Harnett County Government Complex
307 W. Cornelius Harnett Boulevard
Lillington, NC 27546

Re: Status of Improvement Permit Application #17-5-41277

SITE PLAN APPROVAL

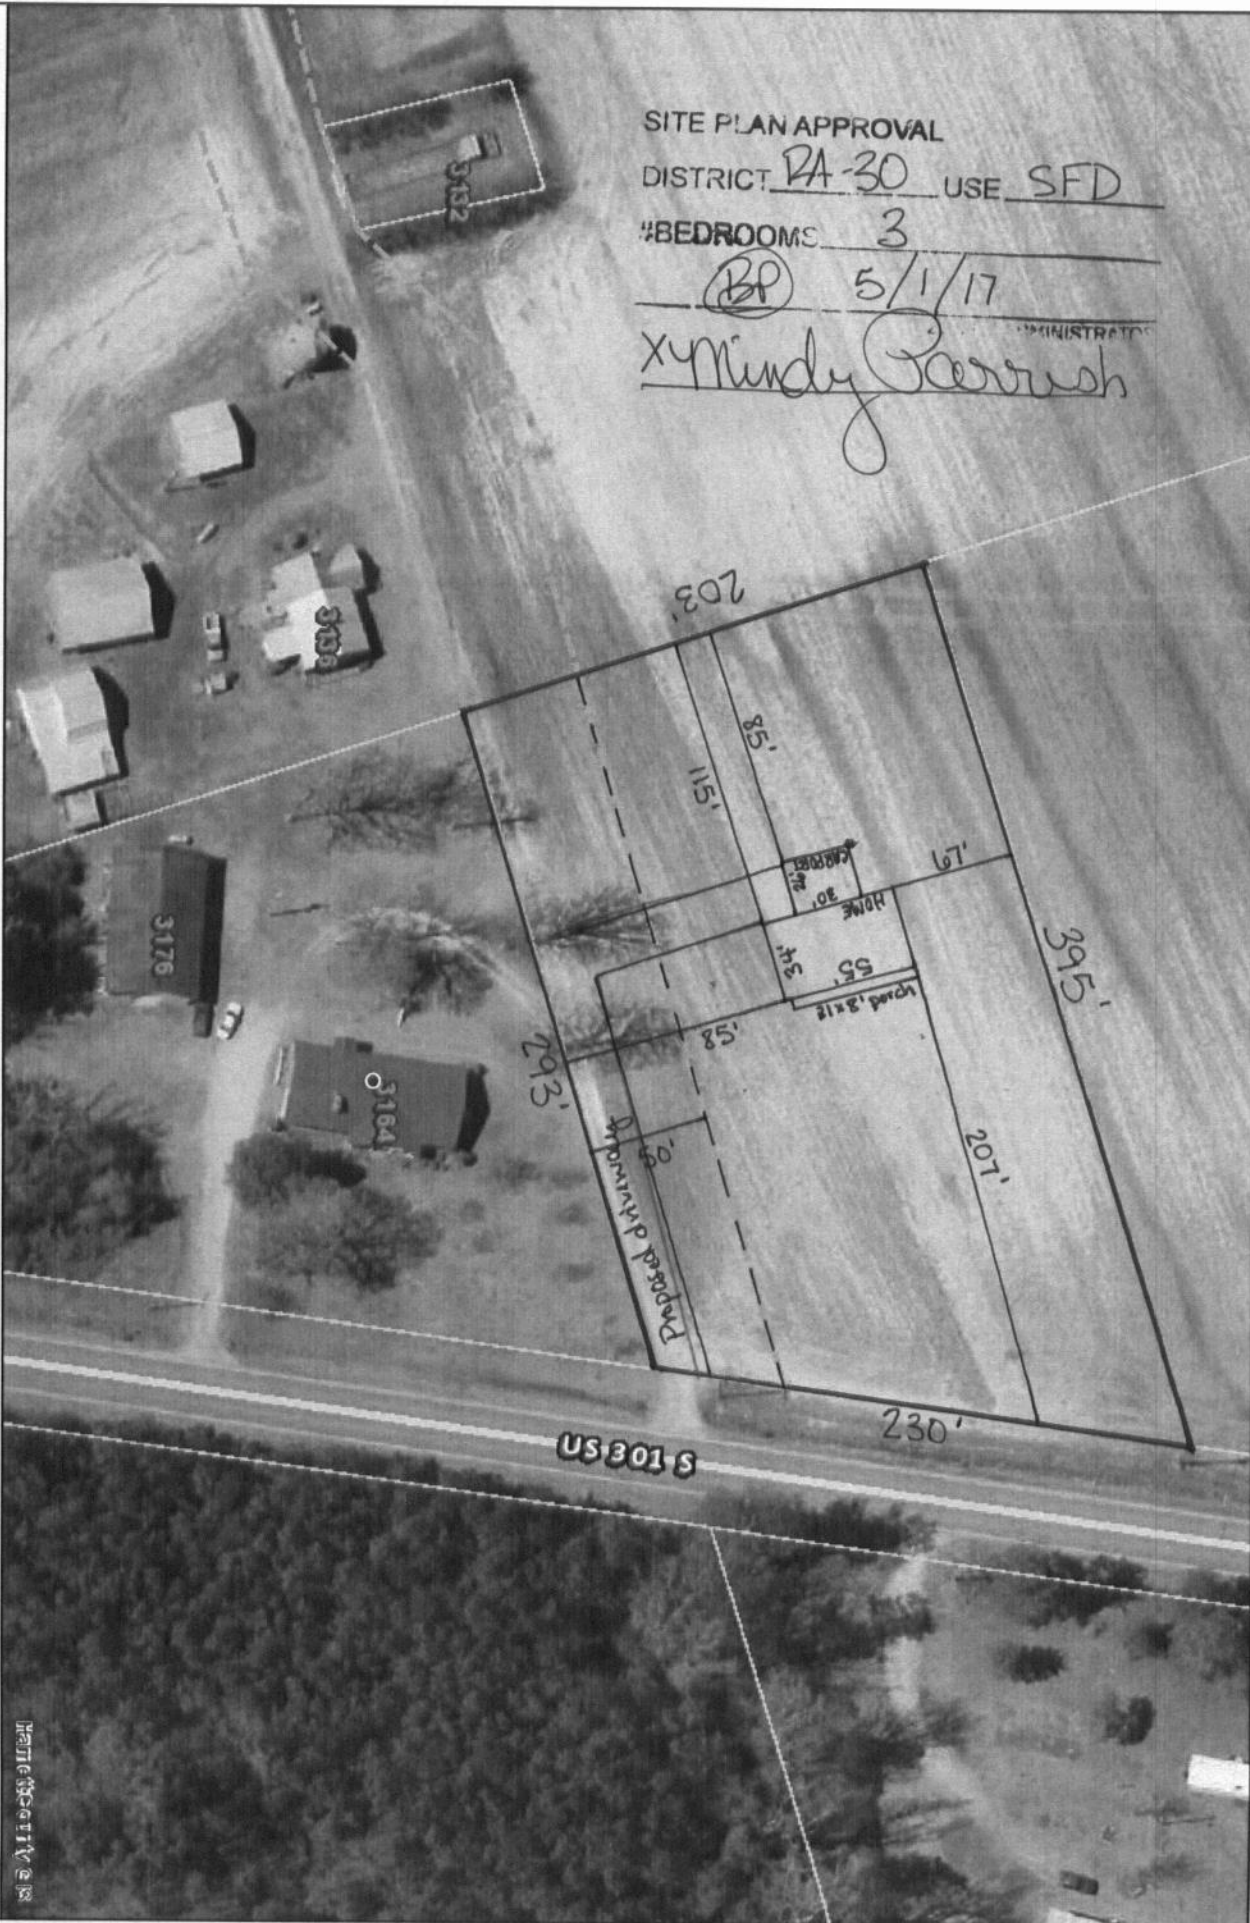
- 1. Use pink flags to mark property lines and irons that are set by surveyor need to be visible – irons need to be visible (\$25.00 fee incurred)**
2. Use orange flags to mark house corners (*\$25.00 fee incurred*)
3. Directions not clear to property (*\$25.00 fee incurred*)
4. Property needs only brush or vegetation removed
5. Driveway not shown on site plan
6. Backhoe pits required
- 7. Other – Incorrect setbacks on front and rear of property. Front should be approx. 180 ft. and rear 125 ft. Please revise application to update the setbacks. Submit changes to Central Permitting.**
